Appeal Decision

Appeal Ref: APP/R4408/D/20/3257231

26 Harry Road, Gawber, Barnsley S75 2PA

- The appeal is made under section 78 of the Town and Country Planning Act 1990 against a refusal to grant planning permission.
 - The appeal is made by Mr Robinson against the decision of Barnsley Metropolitan Borough Council.
 - The application Ref 2020/0487, dated 19 May 2020, was refused by notice dated 10 July 2020.
 - The development proposed is a two storey rear extension.
-

**PROPOSED
REAR ELEVATION**
SCALE 1:100

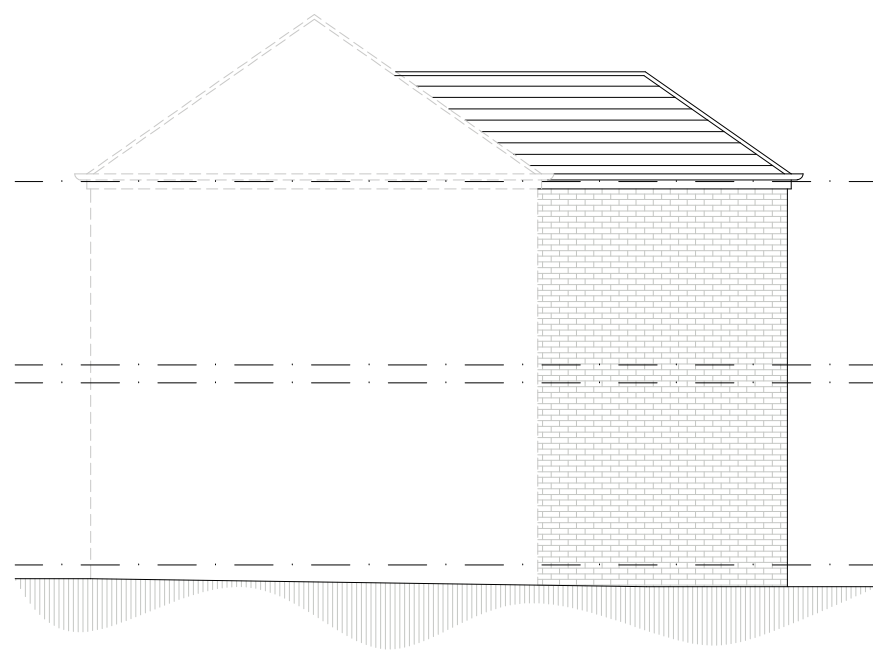
6. The scheme would be marginally set in from the common boundary shared with No. 28. The existing boundary fence is un-intrusive due to its height and gaps between each picket. No. 28 has a ground floor and first floor window close to the common boundary. The existing conservatory, associated with the appeal property, abuts the common boundary and to a small degree impacts the ground floor window.

7. Although the proposed extension would project less than 3.5m, it would not comply with the 45-degree rule. The scheme would have an overbearing impact upon No. 28 because of the depth, siting and height of the proposed two-storey extension. Accordingly, the outlook from No. 28's ground floor and first floor rear windows, adjacent to the common boundary, would be dominated by the development as a result of the height and depth of the proposed extension in proximity to the windows.

8. I visited the site mid-morning and observed that the rear windows of both the appeal property and No. 28 were shadowed, as the sun was to the front of the dwellings. Nonetheless, the proposed extension would result in the loss of sunlight and daylight reaching No. 28's rear habitable rooms, adjacent to the boundary, particularly in the afternoon. This is due to the depth, siting and height of the proposed extension and because the rear elevations of the properties are west facing, and the appeal dwelling is to the south of No. 28.

9. Based on the evidence submitted, the proposed scheme would have a more harmful impact upon the occupiers of No. 28 than the approved scheme as the depth of the two-storey extension, adjacent to the common boundary, would be greater. Similarly, the development would have a greater impact than the existing conservatory due to its height and solid nature.
